CITY OF ALBUQUERQUE

April 13, 2017

RE: R&R Trucking – 7021 Huseman Place SW
Grading and Drainage Plan
Stamp Date: 3/31/17
Hydrology File: M10D016I

**GRADING AND DRAINAGE PLAN**

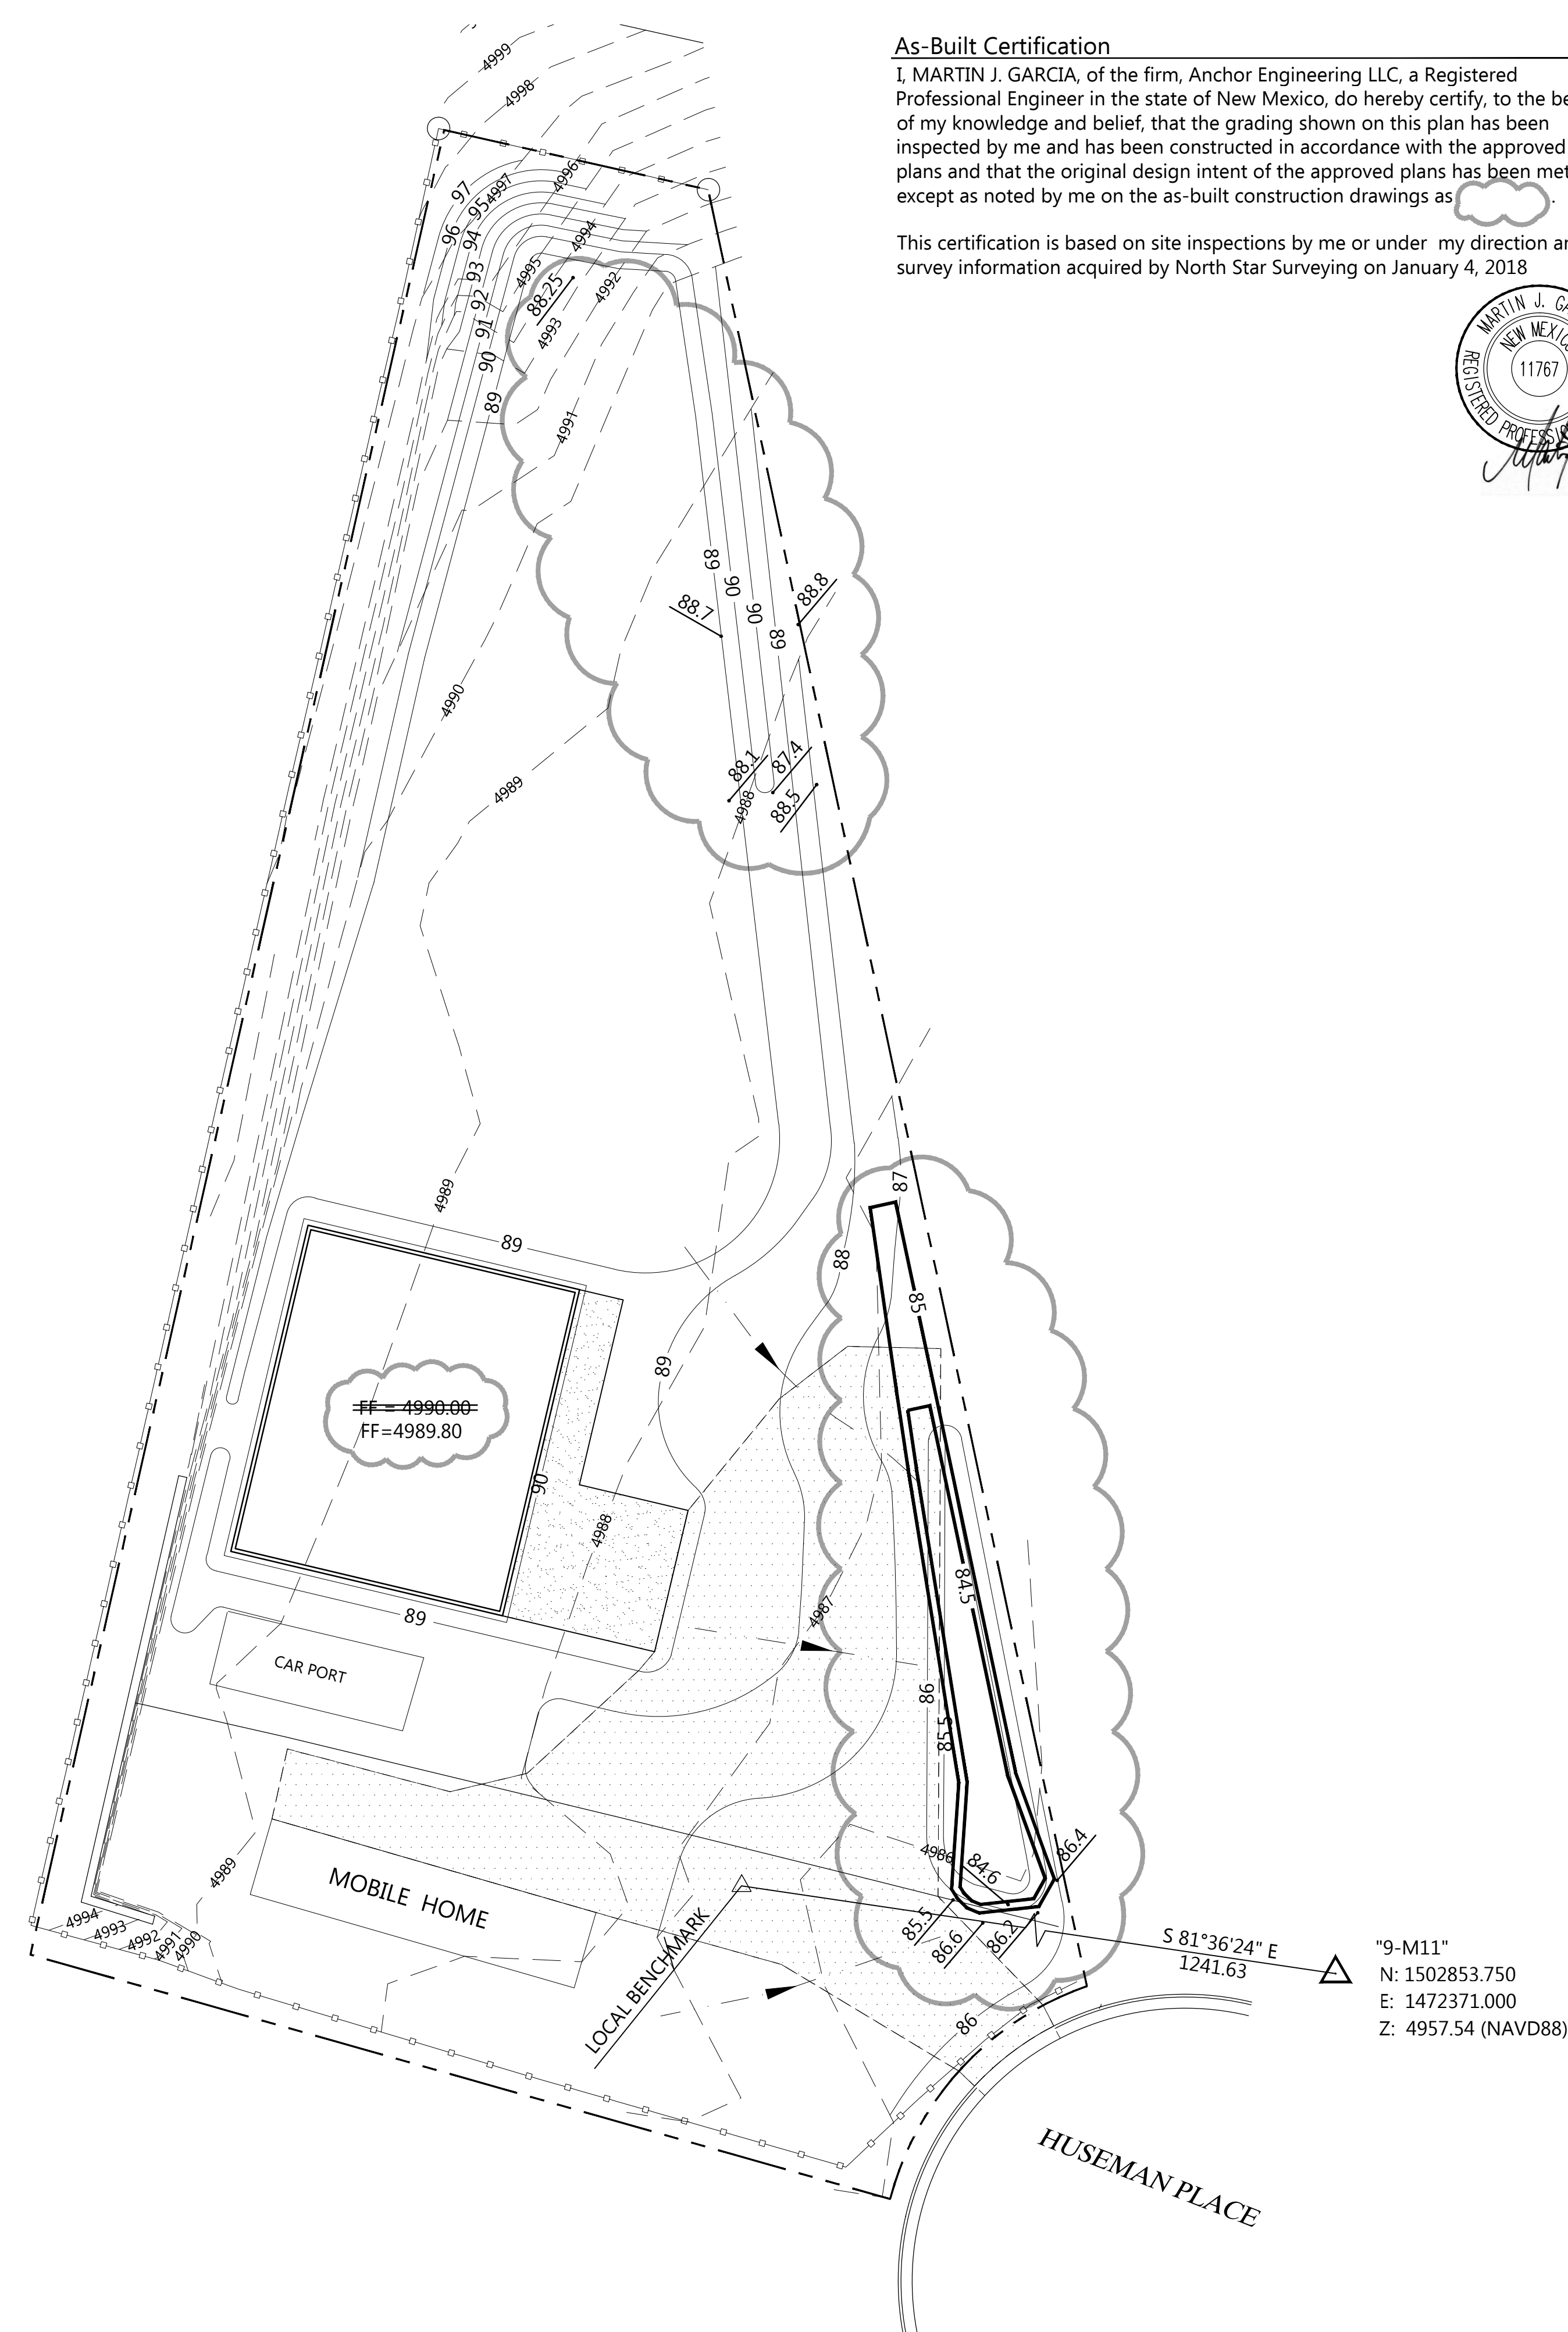
1. There appears to be existing asphalt on the site. Please show it if it exists. This may affect the proposed grading.
2. There appears to be an existing driveway. Please show this if it exists.
3. Under the Drainage Calculations – Existing Conditions, This site appears to have been reworked over the past several years based on historical imagery. If this is the case, than the site is not Type “A” but Type “C”. Also as mentioned in item #1, the existing asphalt is Type “D”. Also the existing carport and mobile home are Type “D”. This should just change the existing runoff.
4. It appears that the majority of the runoff from the proposed building outfalls towards the SE corner of the property before entering the Huseman Place curb drainage system. Please add the first flush basin in this area for the runoff.
